## **A38 Derby Junctions**

### **8.59 Technical Note on Markeaton Junction Northbound Diverge Slip Road – Access to Euro Garages and McDonald's**

<b>Project:</b>	<b>A38 Derby Junctions</b>				
<b>Title:</b>	<b>Markeaton Junction Northbound Diverge Slip Road – Access to Euro Garages and McDonald’s</b>				
<b>Doc ID:</b>	<b>HE514503-ACM-HGN-Z2_JN_J2_J-TN-CH-0002</b>				
<b>Date:</b>	<b>January 2020</b>	Version:	<b>P01</b>	Status:	<b>S0</b>

Drawing Title  
FIGURE 2.6  
MARKEATON JUNCTION  
GENERAL ARRANGEMENT

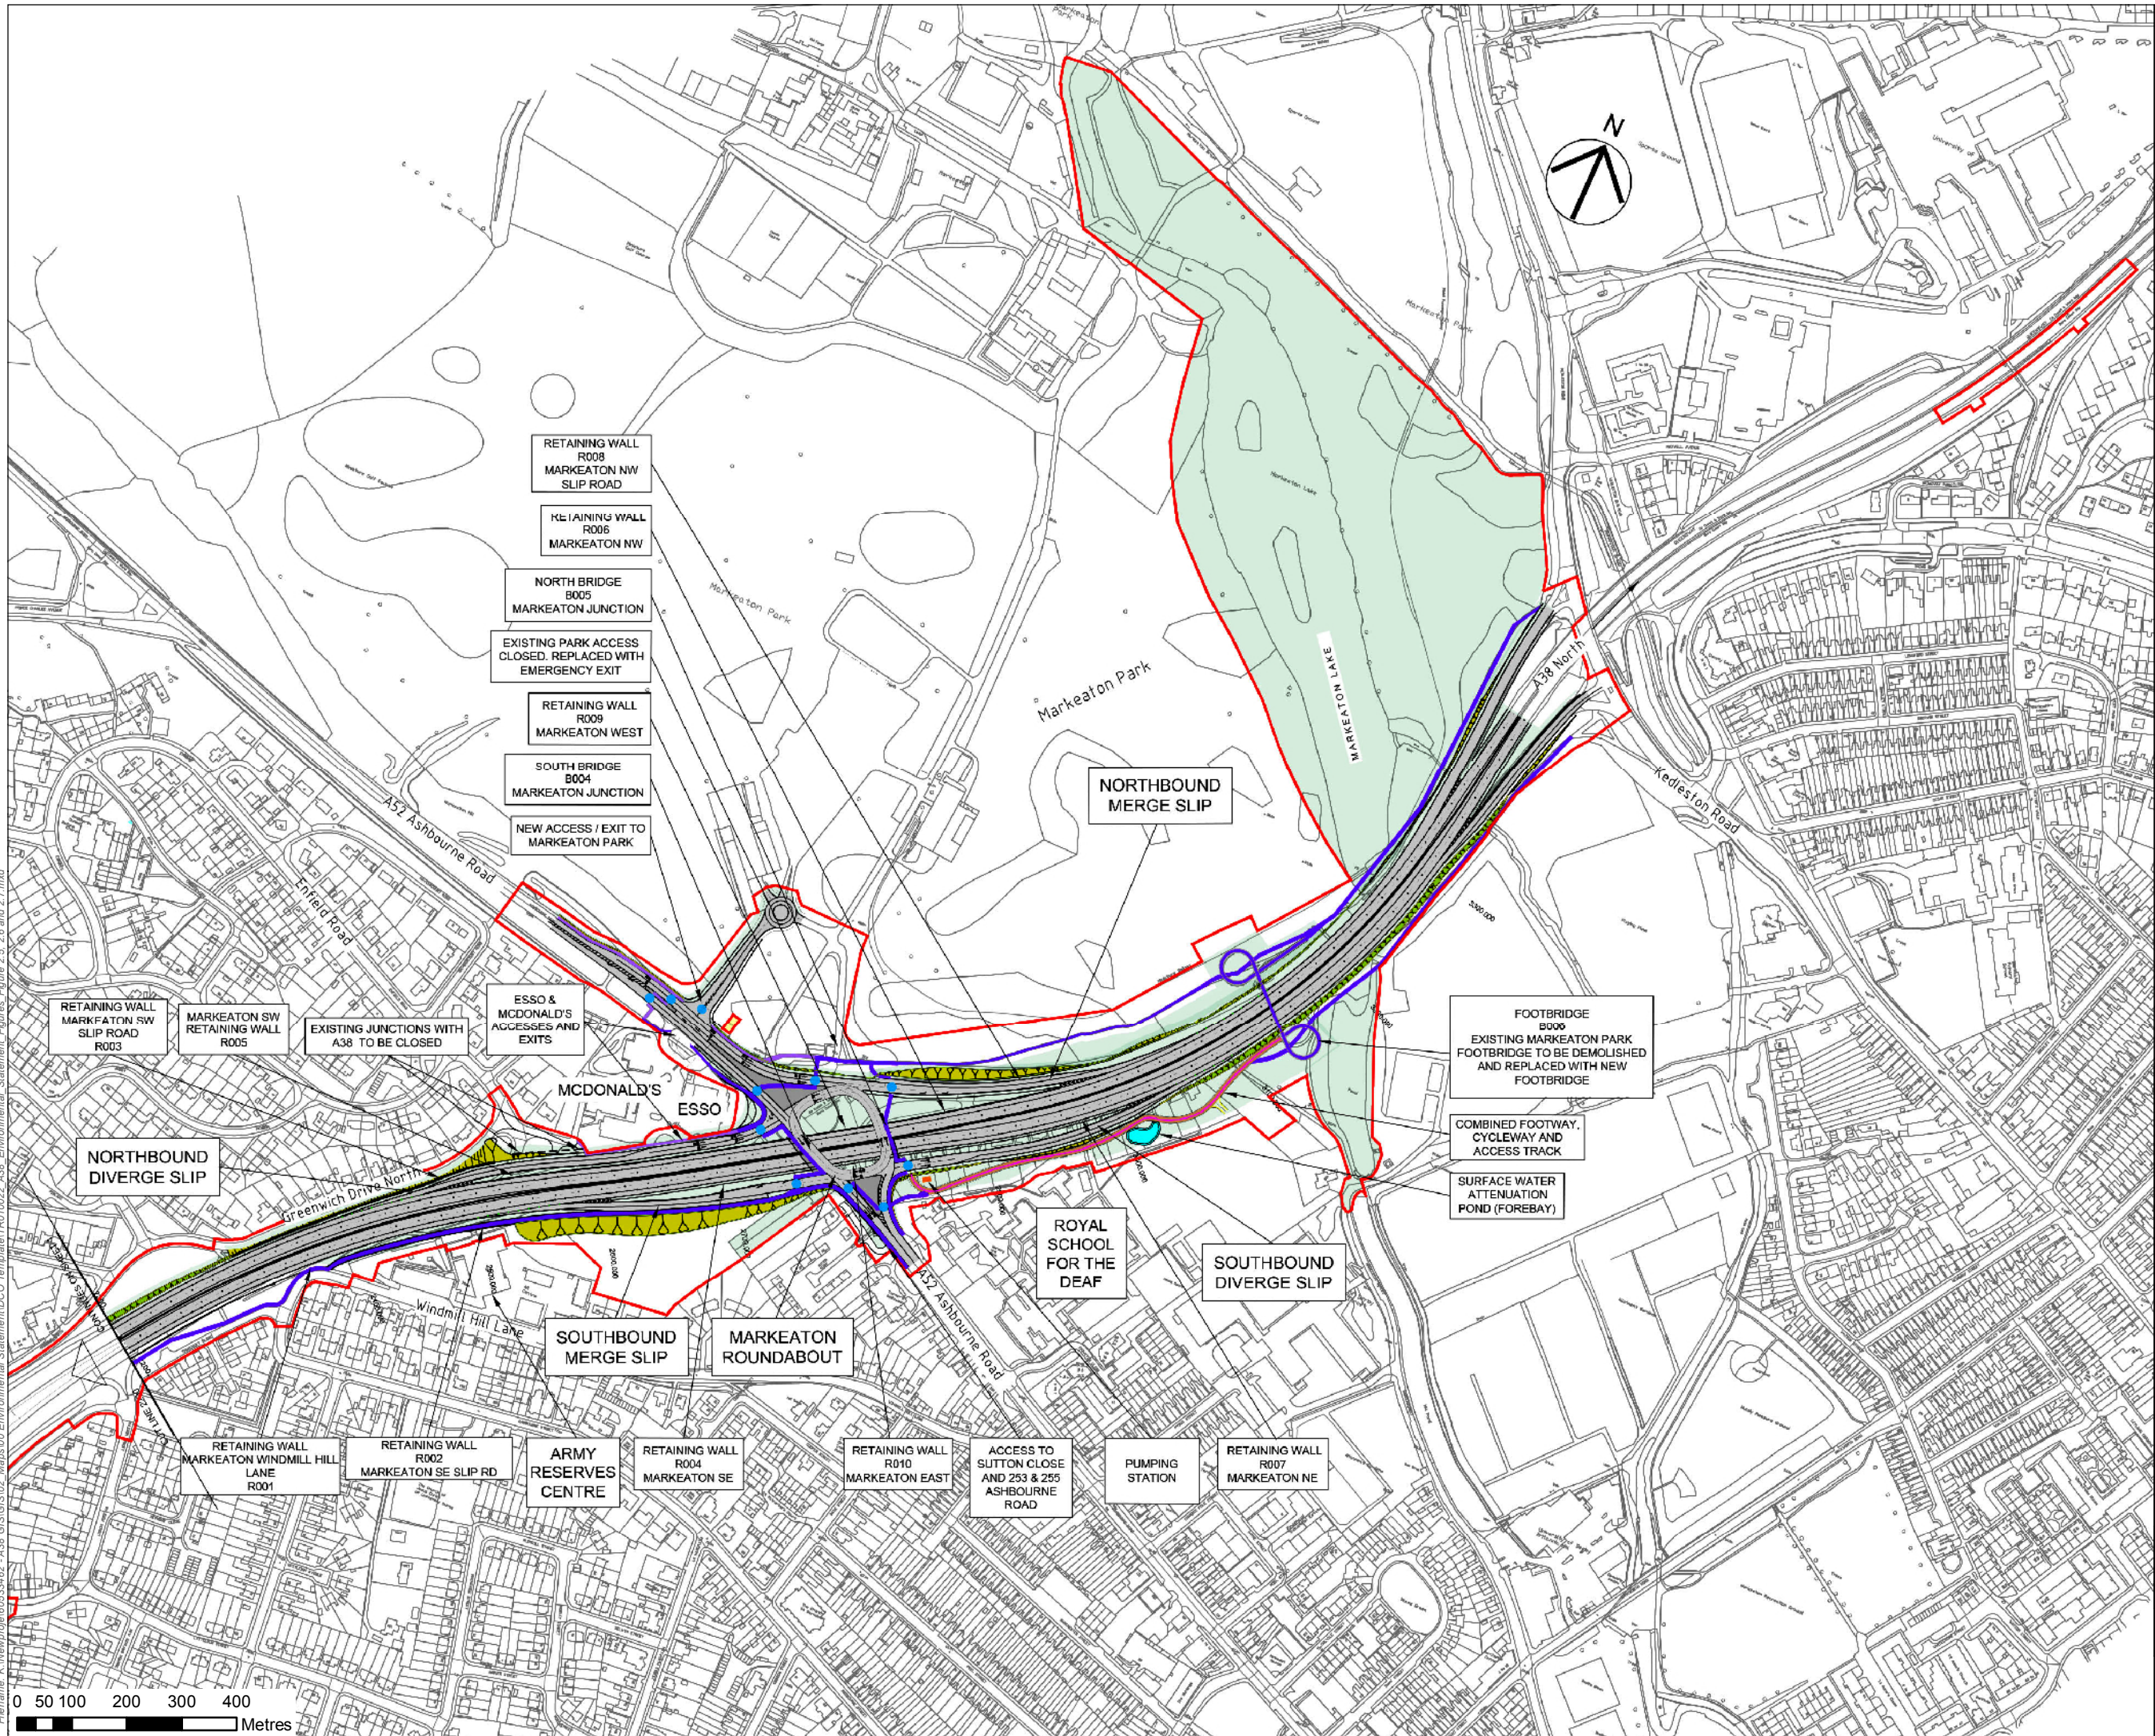
- 
- 4.10 The following summarises the response received following issue of the above to HE SES (SR-D)
- 4.11 Quoting SR-D's email "*Given the level of road user risk associated with the proposed layout (option 7), the fact that there are viable alternatives and the suggested claims are unlikely to be realistic, the 'preferred option' would not meet the basic criteria for DfS approval. If approval was granted, we [Highways England] would not be able to provide a reasonable defence to our decision-making process in the event that it was questioned in a Coroner's Court. Under the Construction (Design and Management) Regulations 2015, the designer has a duty to eliminate foreseeable health and safety risks where reasonably practicable. If we choose to not eliminate such a hazard, then we could be seen to have failed to meet our legal obligations.*

- To conclude, I can confirm that SR-D do not support the preferred option. I appreciate this isn't the answer you were hoping for; however, Highways England's number one imperative is safety and agreement to the proposed layout would mean other factors would be placed above this.*

- Access from the slip road only is an option that we are open to; however, I must stress given the position we are in that in order for this to be approvable it must be possible to demonstrate that the resultant layout represents the best overall option when weighed up against the alternatives. It must also not include an intolerable level of residual risk. While identification of the scale and nature of action required to support a particular development is the responsibility of the development promoter."*

- 4.12 A further meeting with HE SR-D was held in June 2018 to discuss the situation. At the meeting, SES confirmed they were still not prepared to accept an access/egress arrangement with the A38 slip road. They would like to see a sketch showing one-way (access or egress) solution onto the A38 slip road, (egress only onto slip road was progressed as this provides an easier access for A52 traffic and southbound A38 traffic).

- 4.13 A sketch was prepared which underwent several iterations following discussions with SES.
- 4.14 SES confirmed on 02/06/2018 that the concept was viable, and this should be taken forward to the statutory public consultation. This was developed into the sketch layout included in Appendix 2.
